LSC TRANSPORTATION CONSULTANTS, INC.
2504 East Pikes Peak Avenue, Suite 304
Colorado Springs, CO 80909
(719) 633-2868
FAX (719) 633-5430
E-mail: lsc@lsctrans.com
Website: <http://www.lsctrans.com>

Esteban Rodriguez Subdivision Sketch Plan
Master Traffic Impact Study
(LSC #S224630)
August 15, 2023

LSC Responses to EPC TIS Redline Comments

Figure 8
**2044 Background Traffic, Lane
 Geometry, Traffic Control, and LOS**

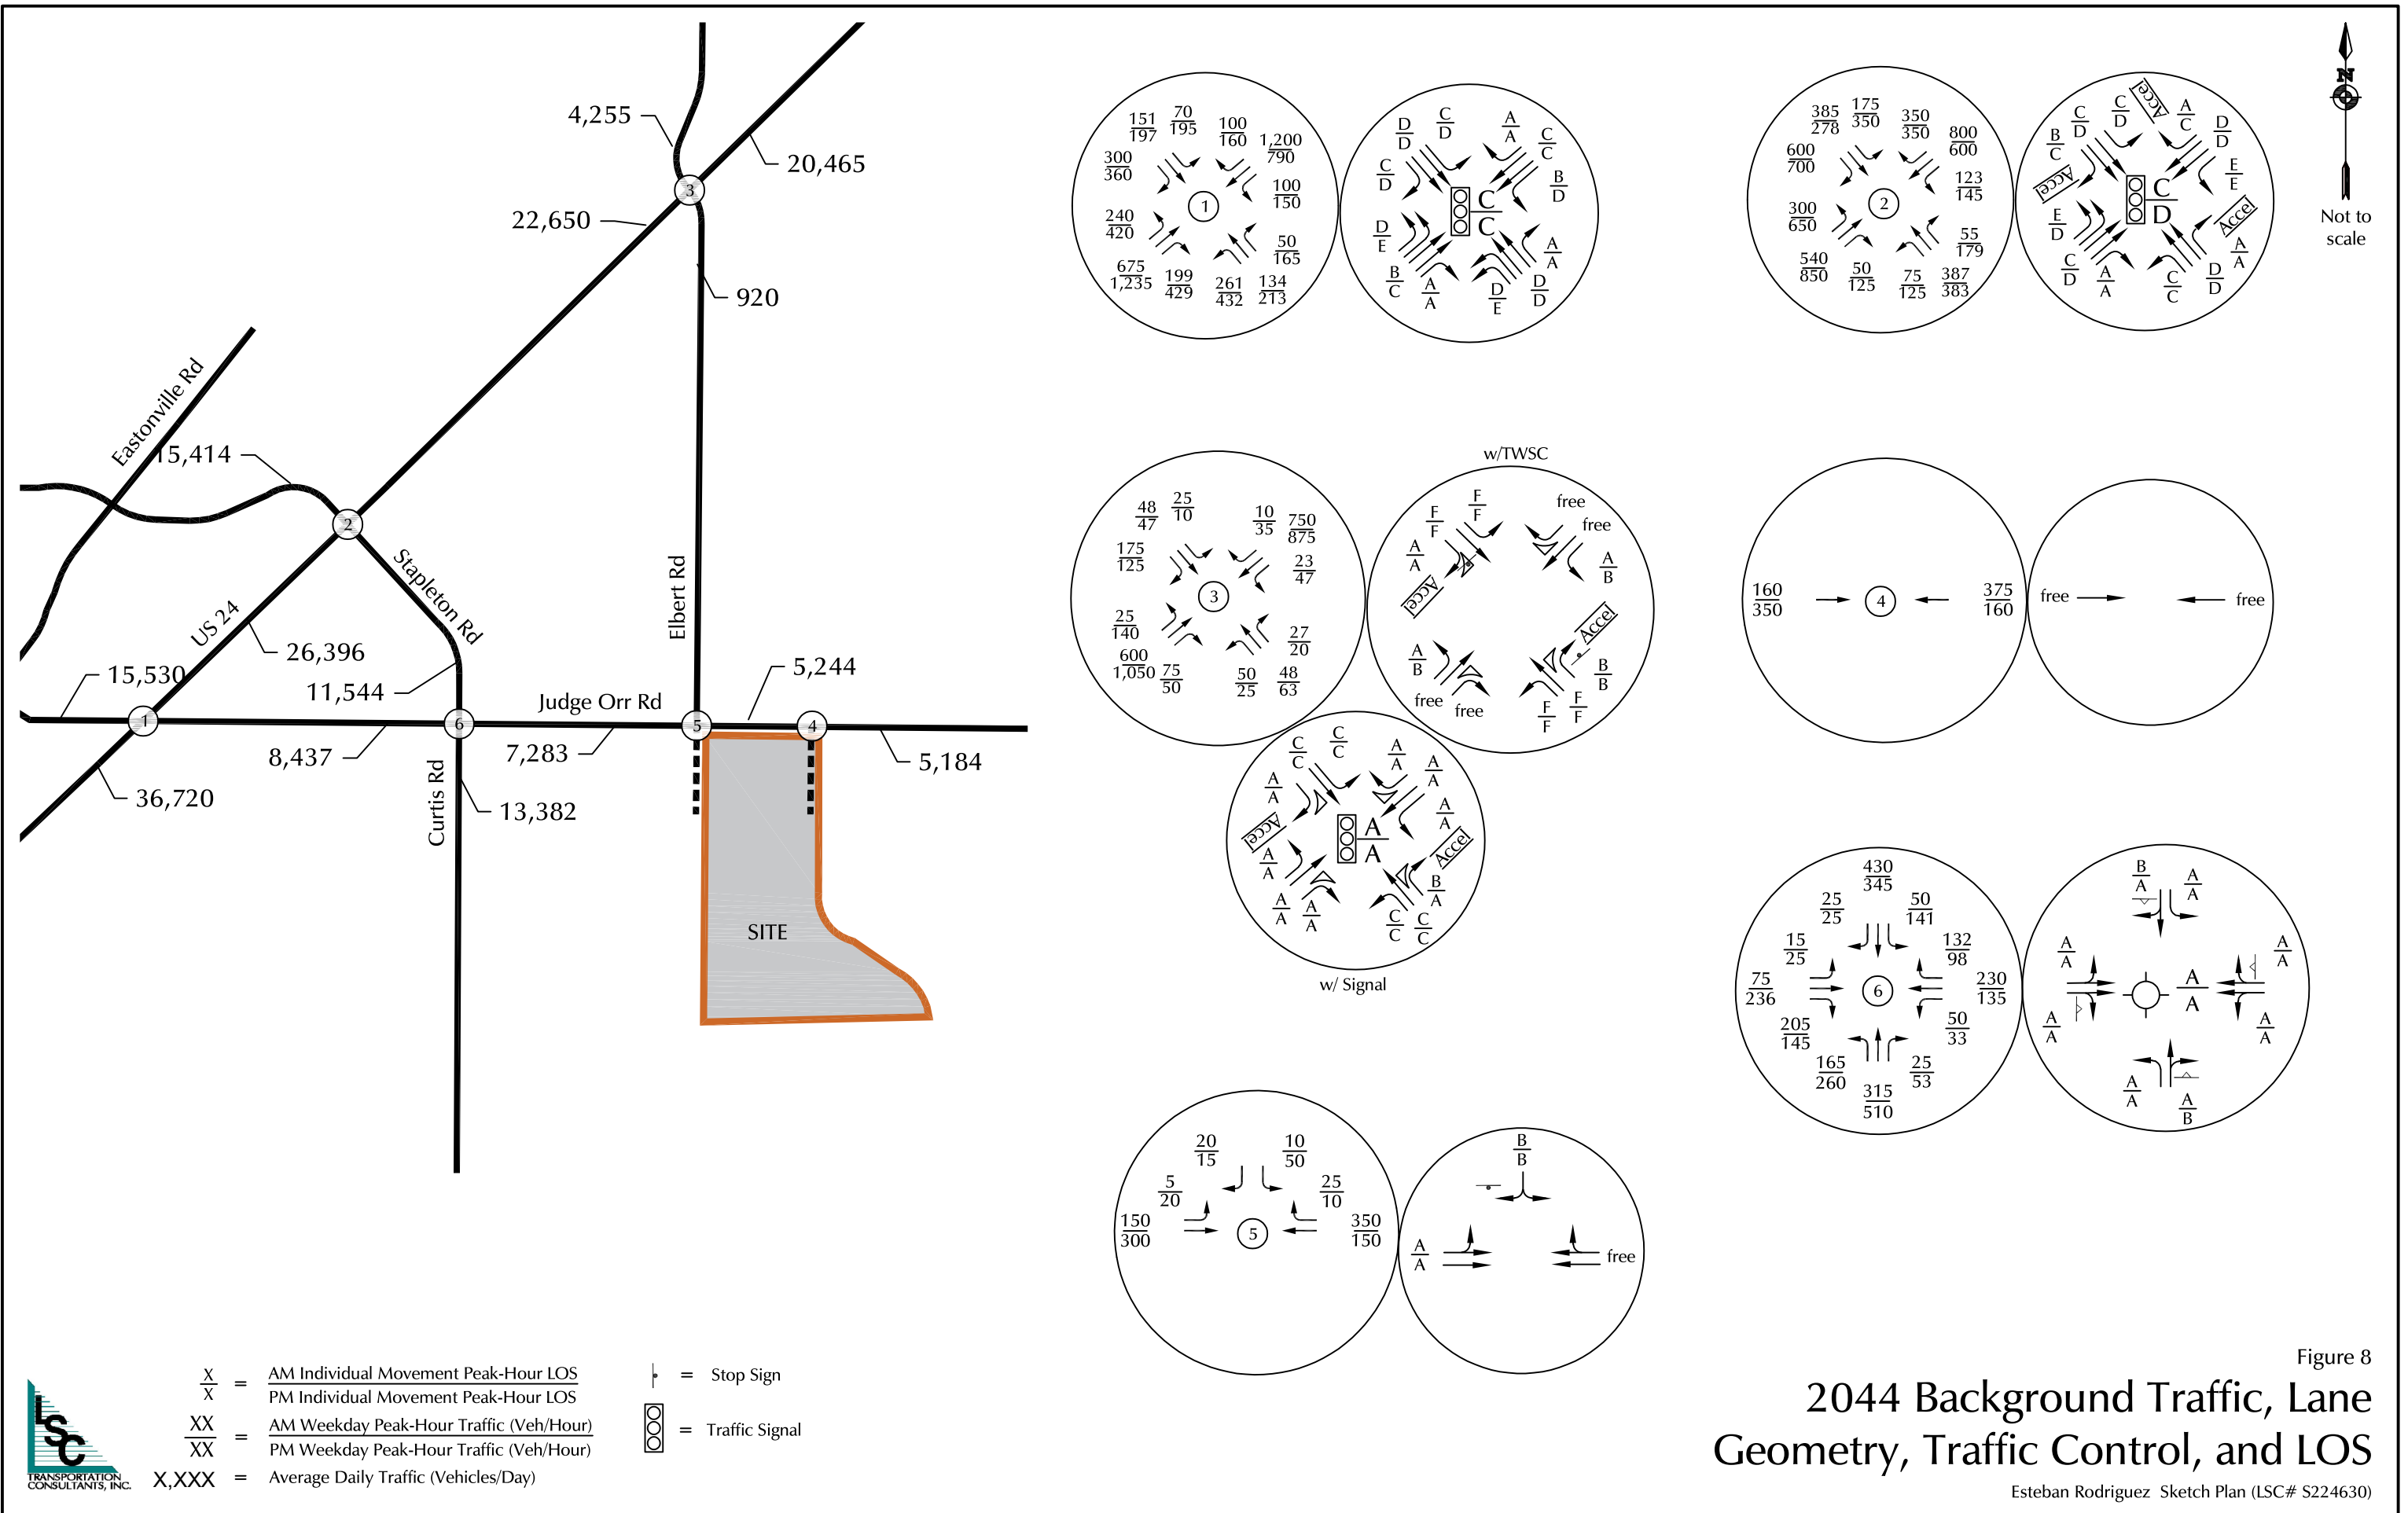
There are some discrepancies between Synchro models, figures, and descriptions about whether Judge Orr Road is a two-lane or four-lane highway at the location of the E Access. Please make this consistent throughout the study.

LSC Response: Figures and LOS analysis results have been updated along with the Synchro models, the figures, and the report narrative.
